Ribble Valley Borough Council
Housing & Development Control

Application no: **3/2024/0187**

Address: **Clayton Manor Ribchester Road Wilpshire BB1 9HU**

Proposal: **Proposed construction of four one-bedroom apartments in a purpose-built detached building with access off Ribchester Road, following demolition of existing garage. Resubmission of 3/2023/0930.**

PROPOSED CLAYTON MANOR APARTMENTS SITE LAYOUT

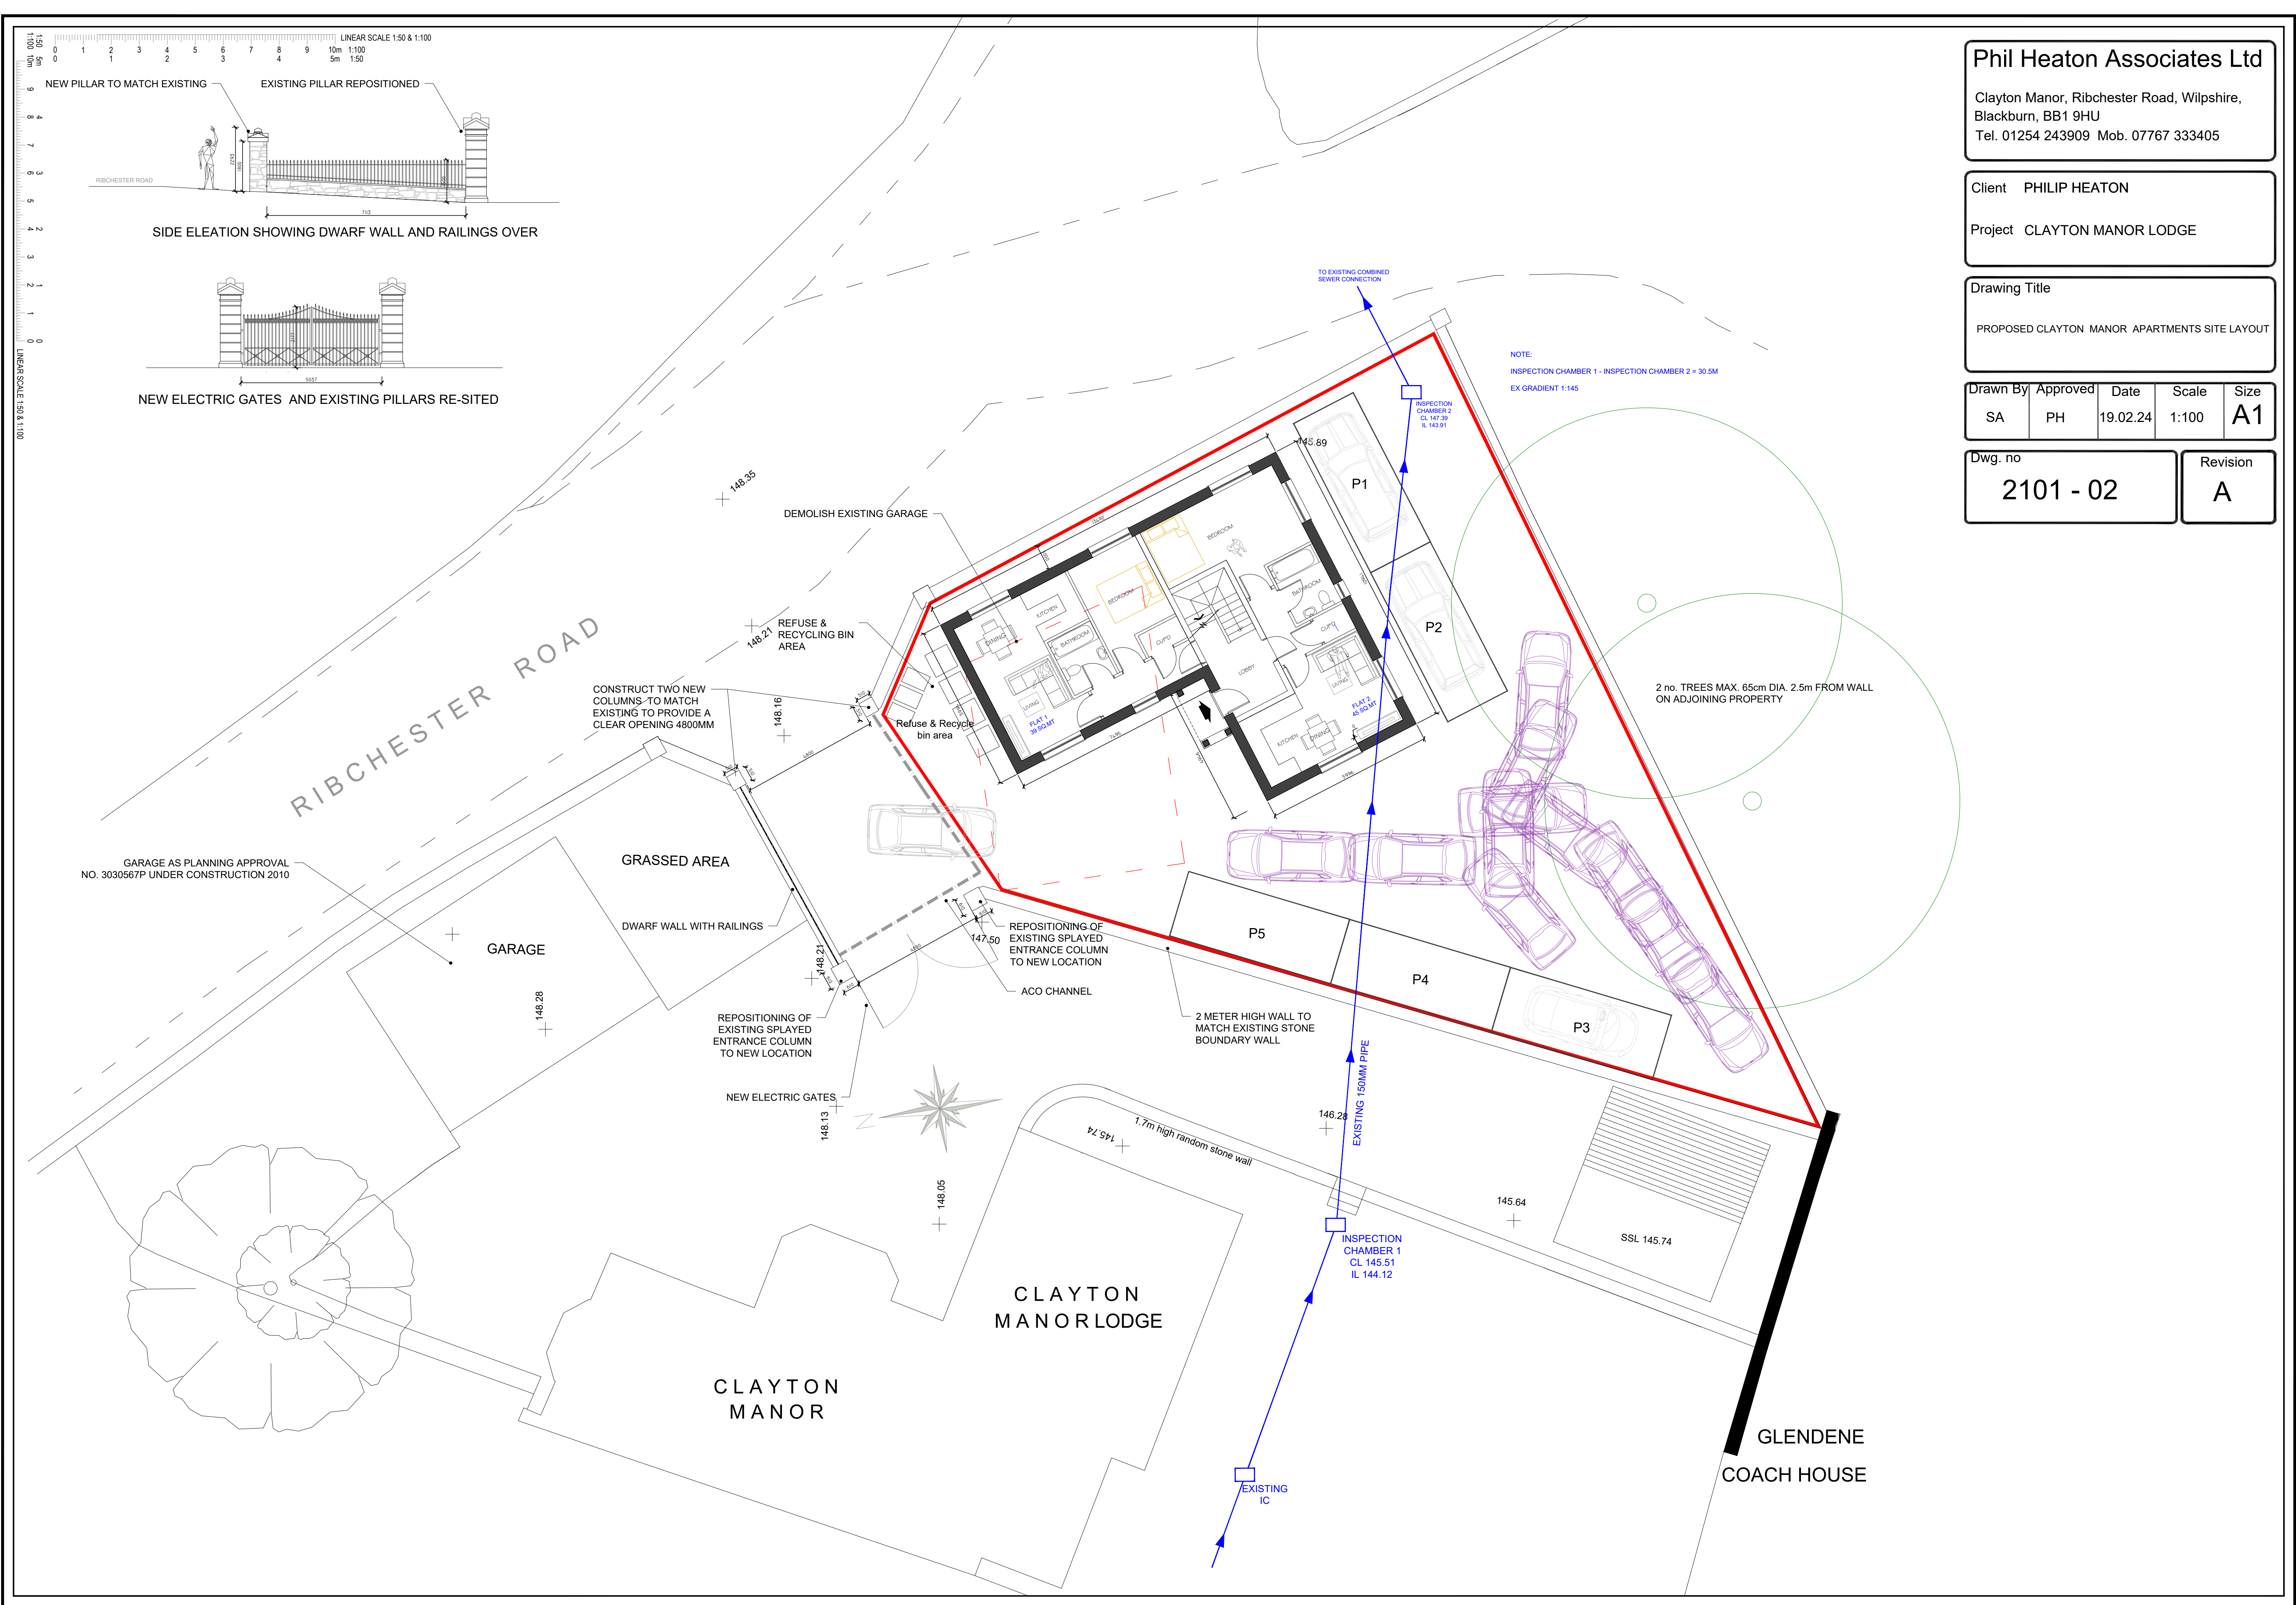
The LHA have reviewed Phil Heaton drawing titled "Visibility Splay 1" dated 14th May 2024 and require the site access to be widened to a minimum of 5.5m wide, up until the access reaches the gated access which serves Clayton Manor, approximately 11.5m away from the adopted carriageway. The LHA require the access to be this wide to ensure that there is adequate space for vehicles to turn into the proposed internal site access which serves the apartment block and to ensure that there is space for two vehicles to use the access simultaneously.

west and 43m to the east. While no amended drawing has been submitted which shows the value to the west, the LHA are unable to accept the shortfall in visibility with speeds likely being higher than the posted 30mph speed limit, given the geometry of the carriageway. The lack of visibility to the west further highlights the unsuitability of the access following the proposed intensification of use.

To overcome the shortfall in visibility to the west, access improvements can be made which removes the stone posts located at the entrance and setting back the boundary wall which fronts Ribchester Road further into the site. Alternatively, the height of the boundary wall can be reduced to 1m to ensure that the visibility splays are not obstructed.

The drawing also provides swept path analysis of a fire tender entering and exiting the internal layout. While the LHA are satisfied that the internal layout has the adequate space to provide an informal turning area for fire tenders and servicing vehicles no larger than 7.2m long alike, the LHA are concerned about the proposed internal access arrangements.

The LHA are concerned because large vehicles will have to immediately turn into the internal access serving the proposed development as they enter the site access. As shown on the tracking drawing, potential conflicts may arise between large vehicles and the boundary wall which separates the existing host dwelling (Clayton Manor) from the proposed site, as well as the gate provided at the access serving the proposal when turning into the site.

To overcome the LHAs concerns associated with the access, access improvements can be made which includes widening the access to 5.5m wide until it reaches the internal access serving the host dwelling. Clayton Manor. And removing the stone posts located at the site entrance as well as relocating the boundary wall fronting Ribchester Road further into the site. Or alternatively reduce the height of the boundary wall to 1m to ensure that visibility splays of 2.4m x 43m can be provided in both directions.
